Approval of details reserved by condition imposed under ref AL/64/20/PL relating to Condition Nos 5 - pre-commencement site meeting with Tree Officer, 6 - mitigation method statement, 7 - archaeology, 8 - Construction & Environmental Management Plan, 13 - detailed level survey, 14 - materials & finishes, 15 - details of all new screen walls & fences, 16 - landscaping, 18 - energy efficiency measures, 19 - covered & secure cycle parking spaces, 21 - broadband, 22 - charging of electric vehicles and 25 external lighting.

Springfield Hook Lane Aldingbourne PO20 3TE

Condition Number 6

Arun District Council have decided to **APPROVE details reserved by this condition**

PROPOSED HEDGEROW PROTECTION PLAN
(1:200)

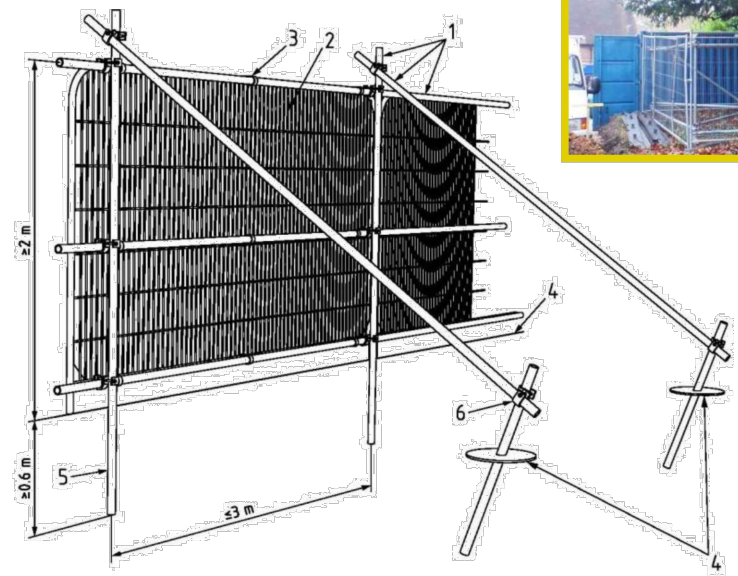
This condition requires a mitigation method statement to provide details of how those retained hedgerows are to be protected & enhanced and to show a 5m buffer zone around the retained hedges. You have now provided an Arboricultural Method Statement alongside the previously submitted "Proposed Landscape Plan" (in two parts - drawings 13 and 14 Rev A) and drawing 02 "Proposed

Hedgerow Protection Plan".

The Councils ecologist has not responded to the re-consultation request following submission of the method statement but it is clear that you have fulfilled the started requirements of the condition and it would not therefore be reasonable to withhold approval. The condition is therefore formally discharged on the understanding that the hedge will be protected throughout the construction process and enhanced in accordance with the landscape scheme.
